From: Contact Centre (CRM) <contact@ribblevalley.gov.uk>
Sent: 17 December 2024 08:27
To: Planning
Subject: Planning Application Comments - 3/2024/0999 FS-Case-671165016

Planning Application Reference No.: 3/2024/0999

Address of Development: Rossendale House York Street Clitheroe BB7 2DL

Title:  
Proposed Site Plan

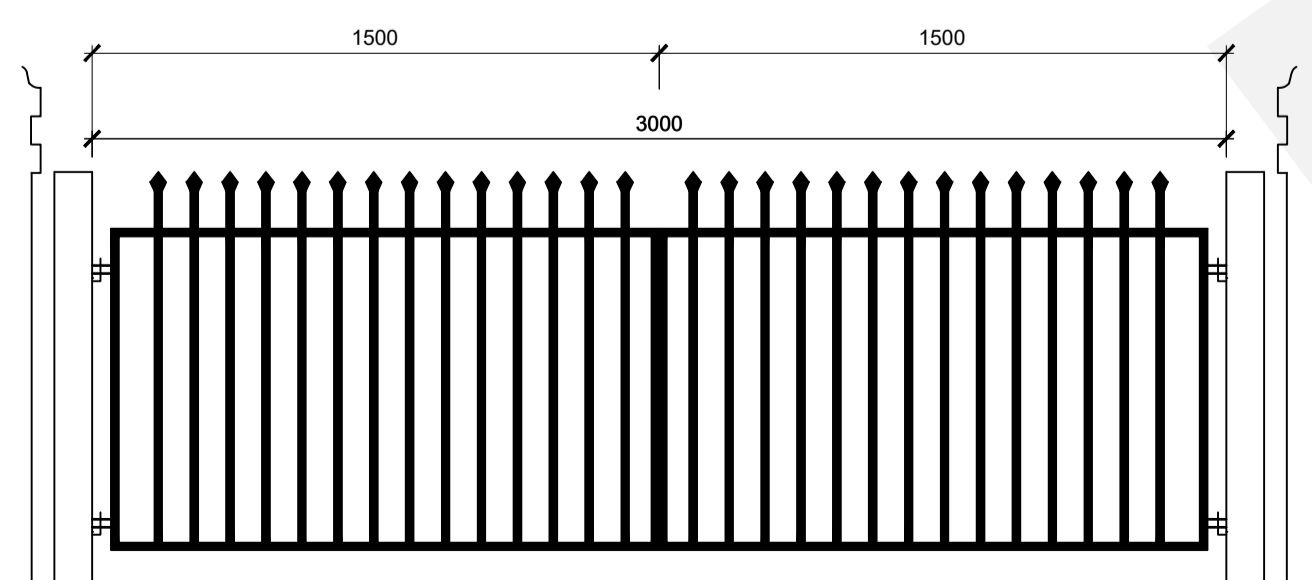
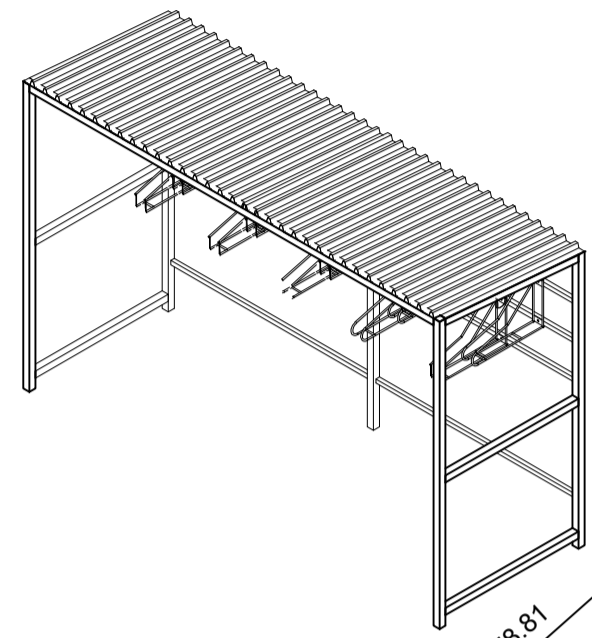
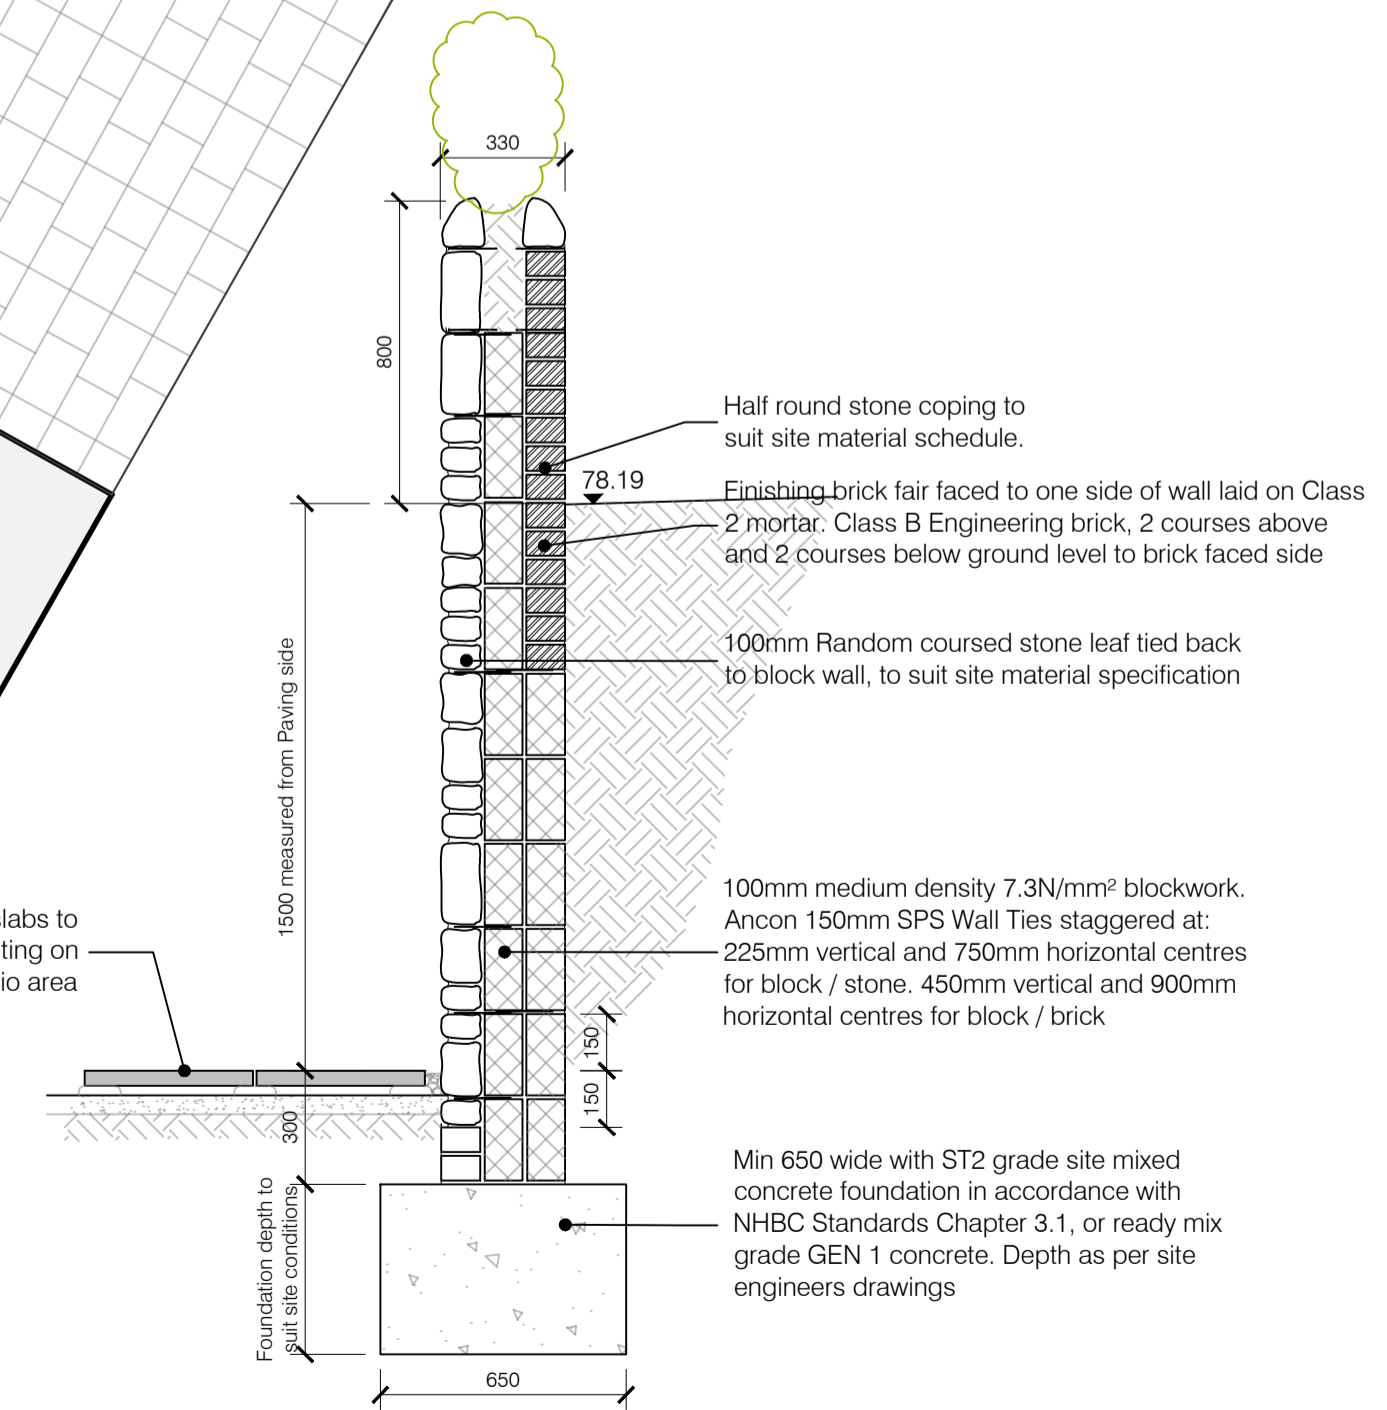
Comments: The initial planning application 3/2033/0827 had car parking provision for 6 vehicles on site. This latest version has no on site parking. As a [REDACTED] [REDACTED] to this development I am very concerned about the ability of customers to our [REDACTED] and other [REDACTED] at [REDACTED] [REDACTED] to find parking. This planning application will contribute to an already congested parking situation, and will directly impact trade to our business and the development must include on site parking as previous.
